CITY OF ALBUQUERQUE

March 5, 2018

RE: **Taos II @ The Trails**
Amended DMP for Release of Financial Guarantee
Stamp Date: none
Hydrology File: C09D001G

**TAOS II AT THE TRAILS**  
**GRADING PLAN**

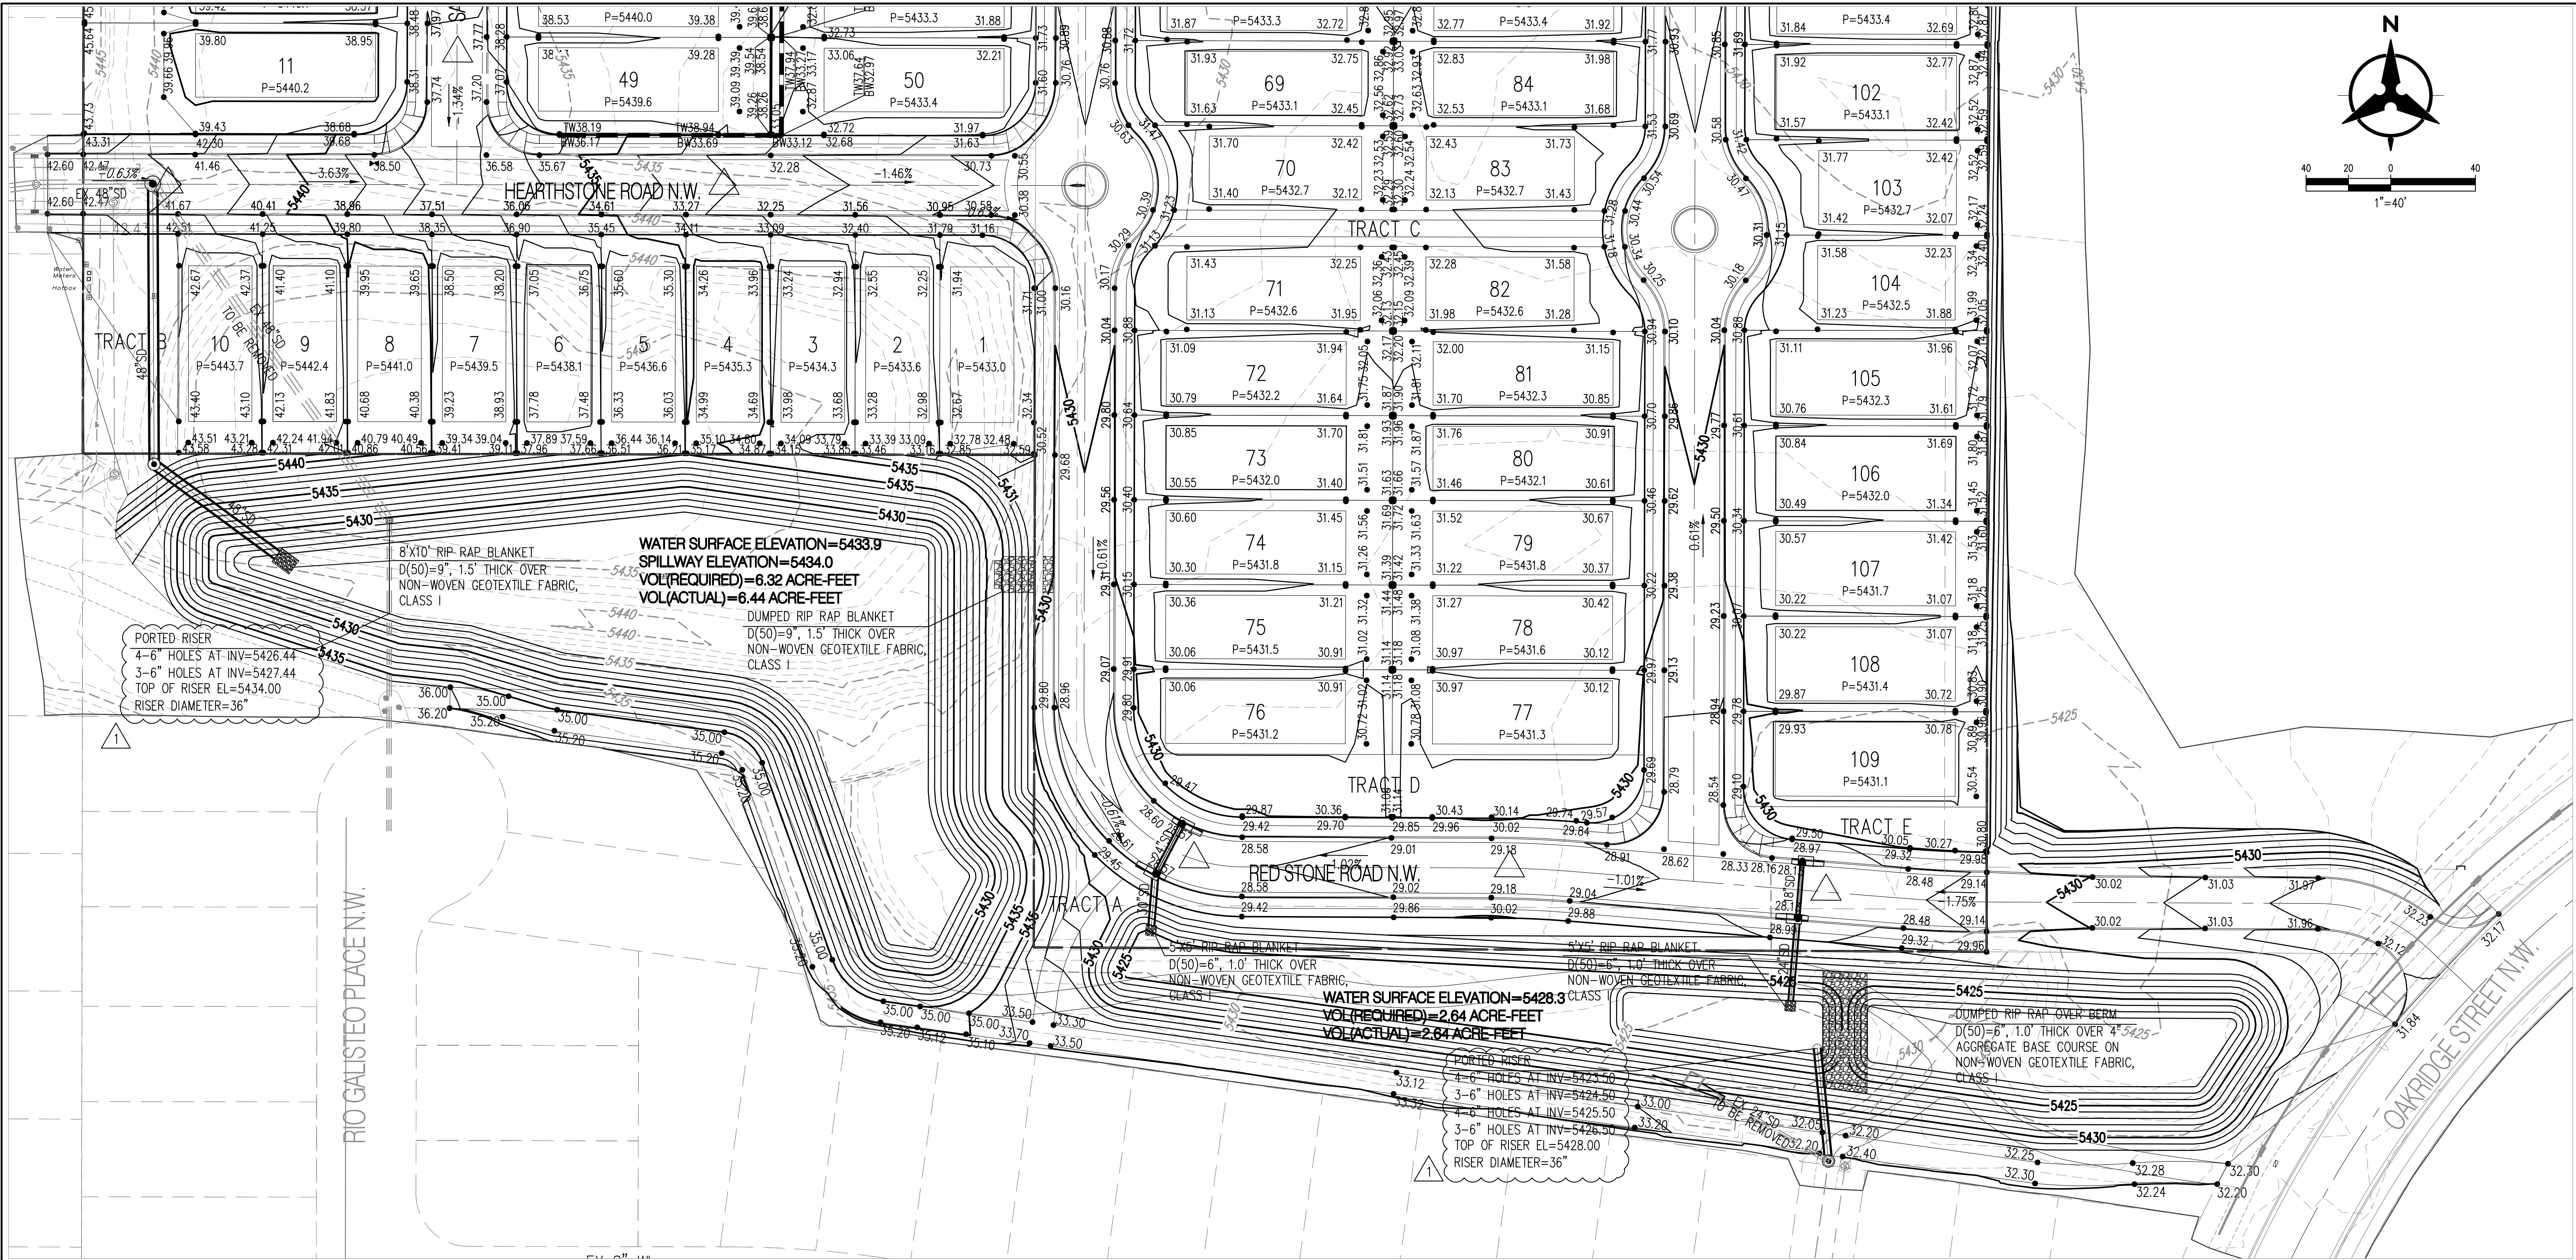
6. Pond F-5 needs to be constructed in compliance with the approved grading plan, dated 1/11/2017, unless an amended grading plan is submitted to Hydrology and approved.
7. As-built survey data should be provided on the Engineer's Certification.
8. As no Engineer's Certification (for ROFG) has been submitted, this is only a partial list based on information provided by RESPEC. Additional items of concern were provided at final walkthrough and will need to be resolved as well.

### POND 'F-5' OUTLET RISER DETAIL

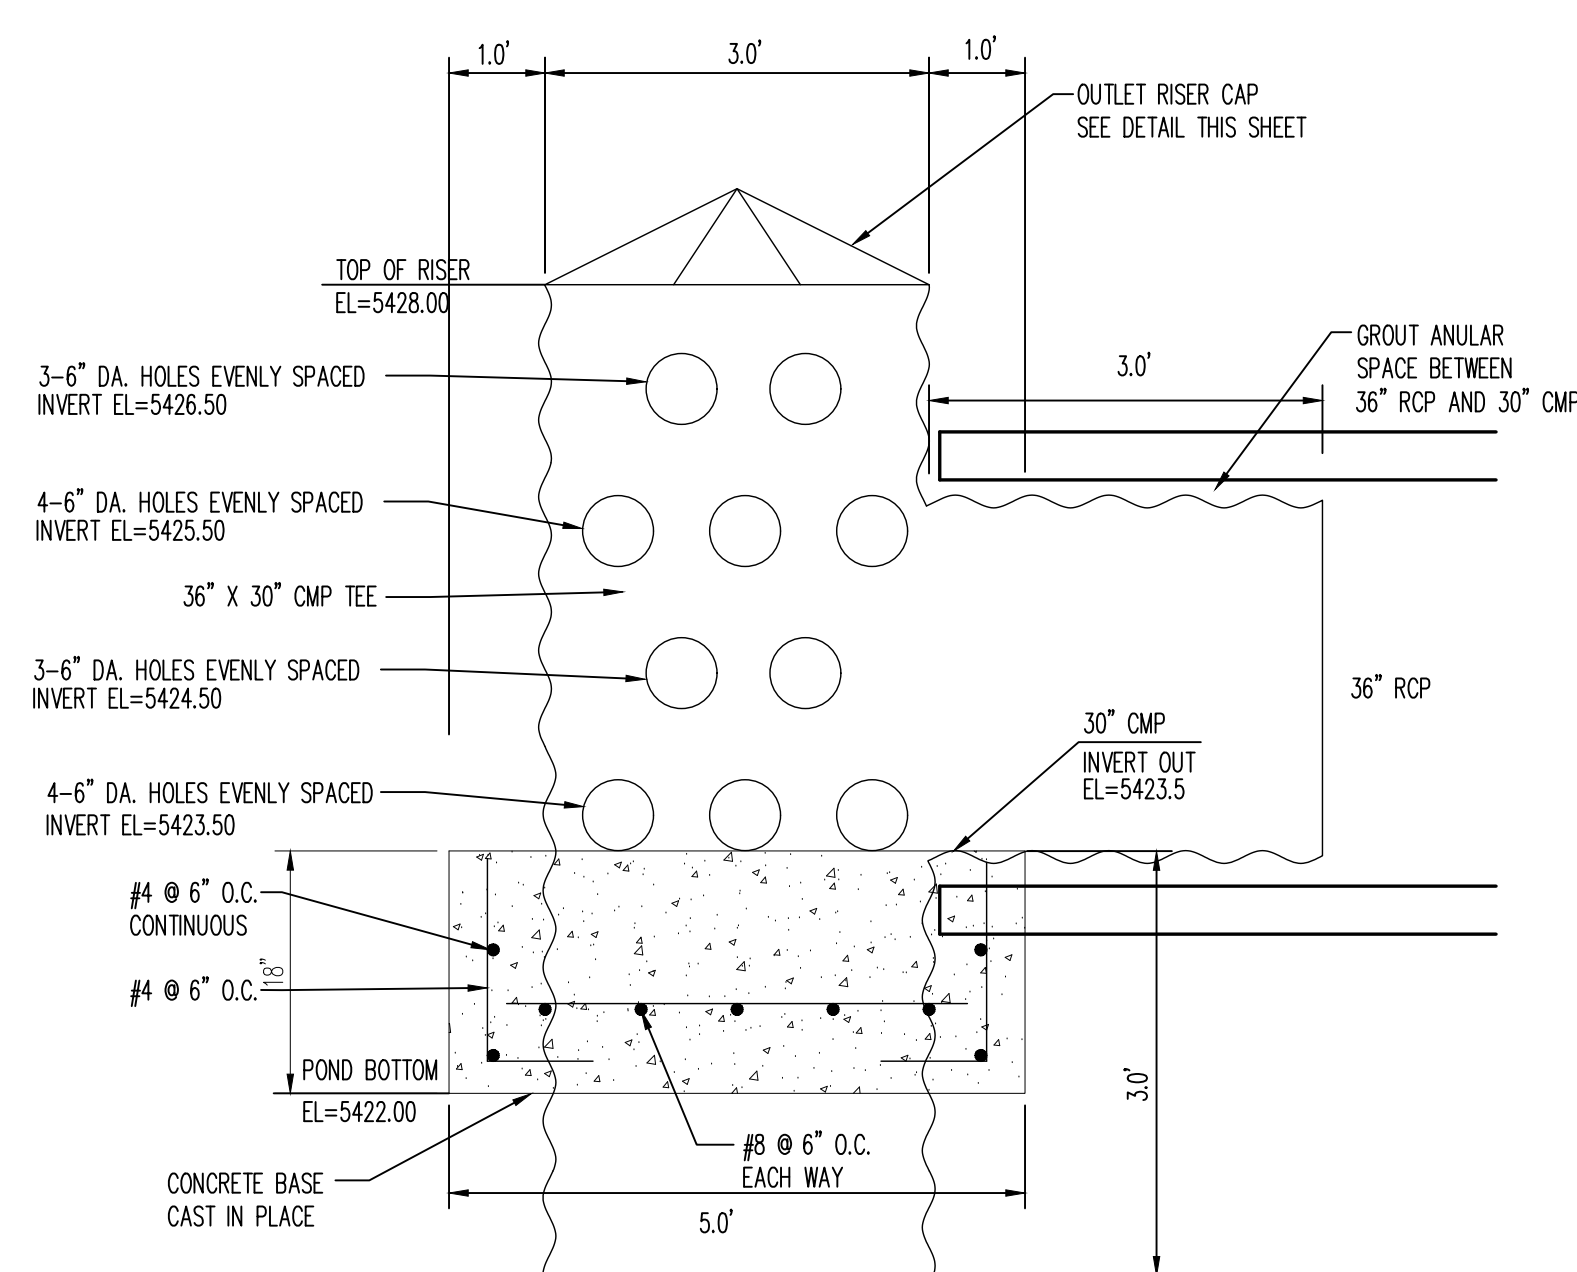
2. Pond F-5 must demonstrate substantial compliance with the approved Trails Master Plan (last updated 2/10/2017). Demonstrate that the maximum outflow is 46.43 cfs or less. Additional documentation on Pond F-5 should show: maximum water surface elevation, storage, dead storage to accommodate first flush volume, and freeboard of at least 1'. As-built survey needs to be provided to support the above.

3. It is unlikely that the City will accept the ported risers with excessive welds and unknown structural integrity. Instead of welding the holes back in, it is recommended that new risers be provided in accordance with the original approved construction drawings.

### POND 'D' OUTLET RISER DETAIL

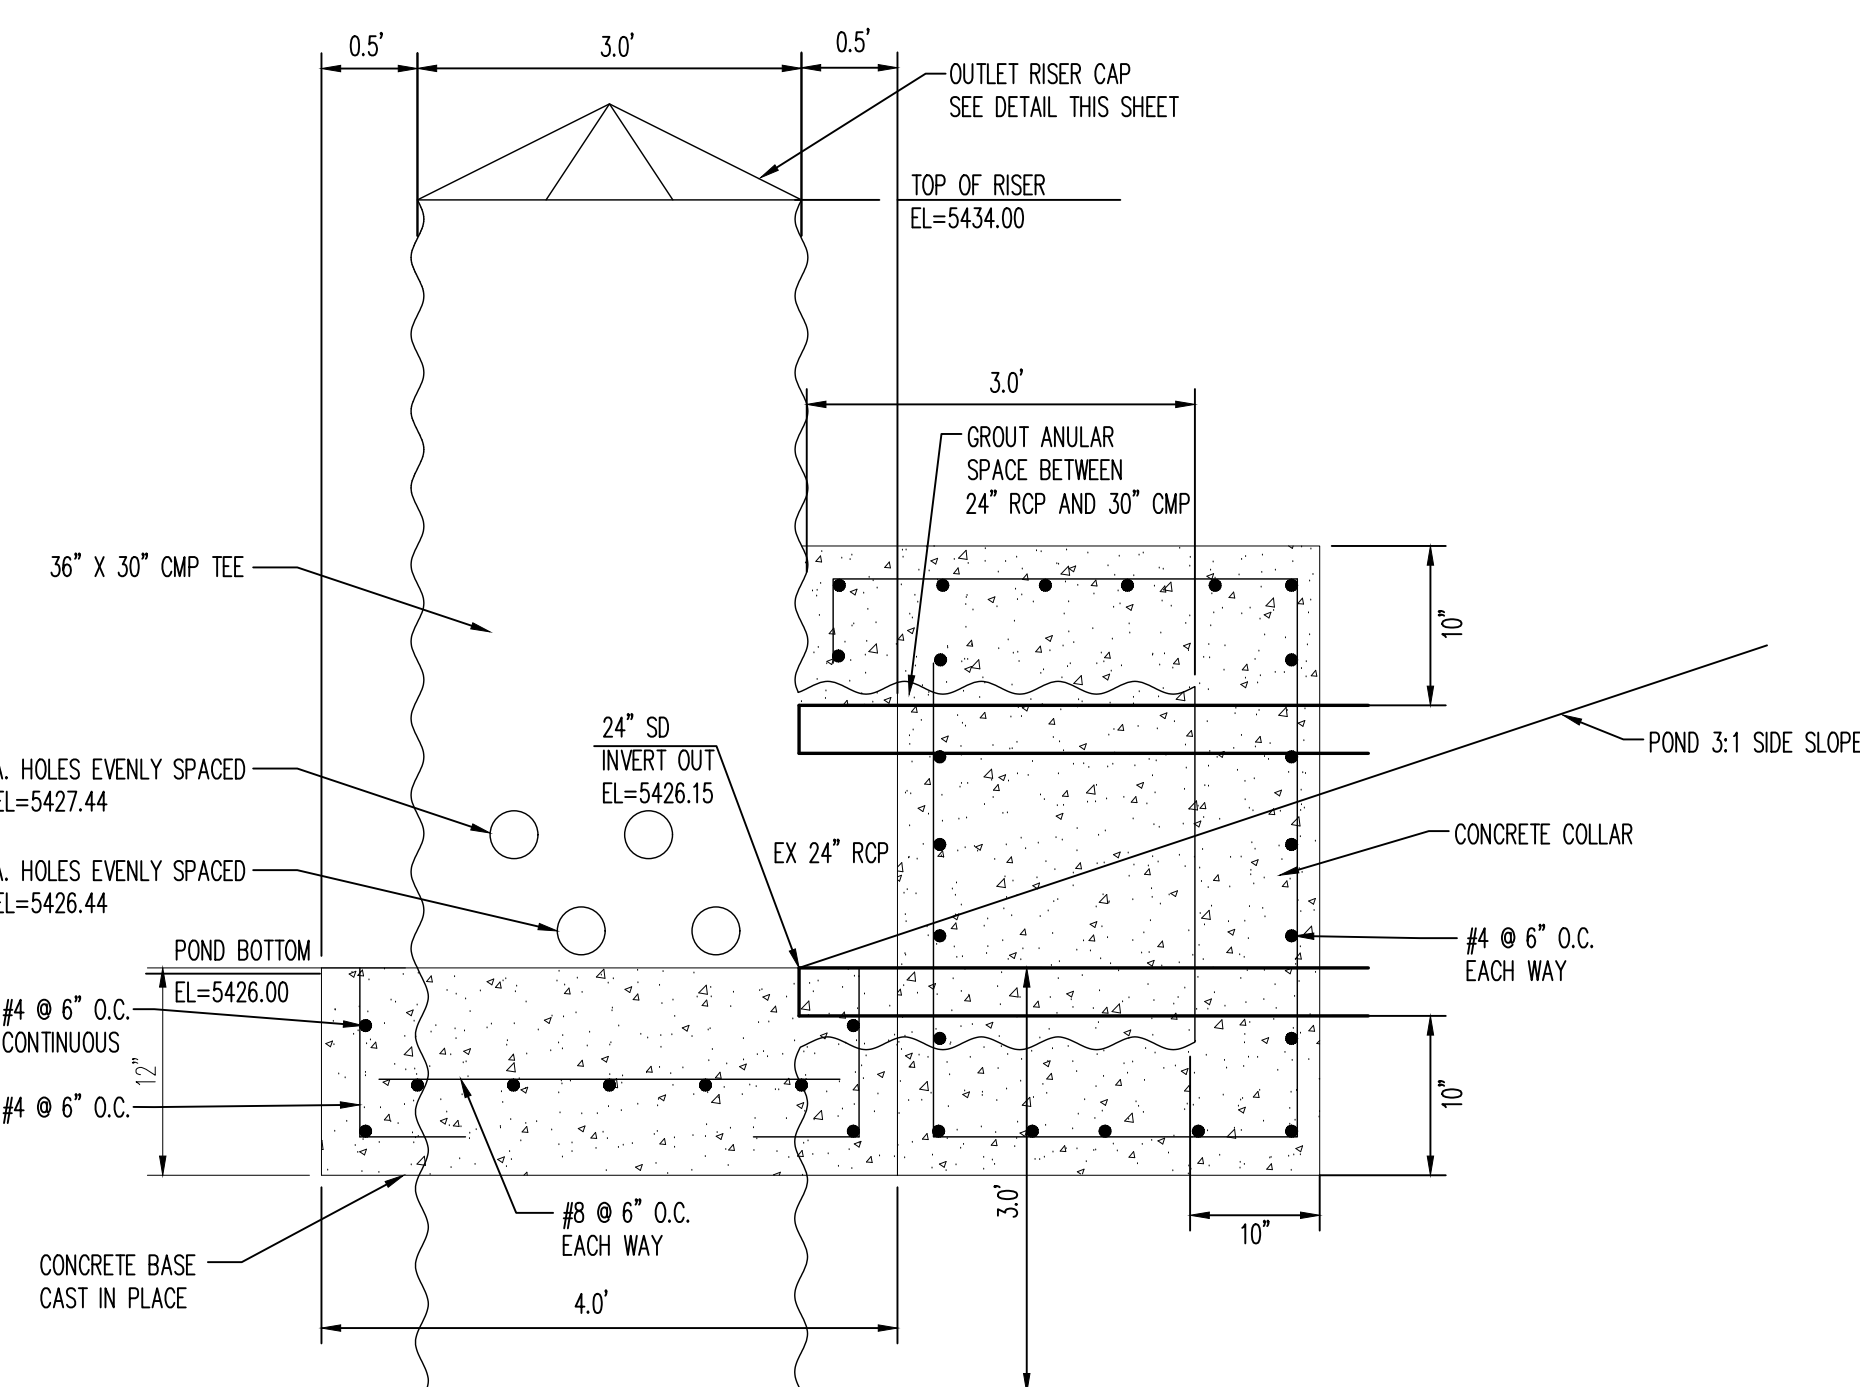
1. Pond D must demonstrate substantial compliance with the approved Trails Master Plan (last updated 2/10/2017). Demonstrate that the maximum outflow is 14.80 cfs or less. Additional documentation on Pond D should show: maximum water surface elevation, storage, dead storage to accommodate first flush volume, and freeboard of at least 1'. As-built survey needs to be provided to support the above.
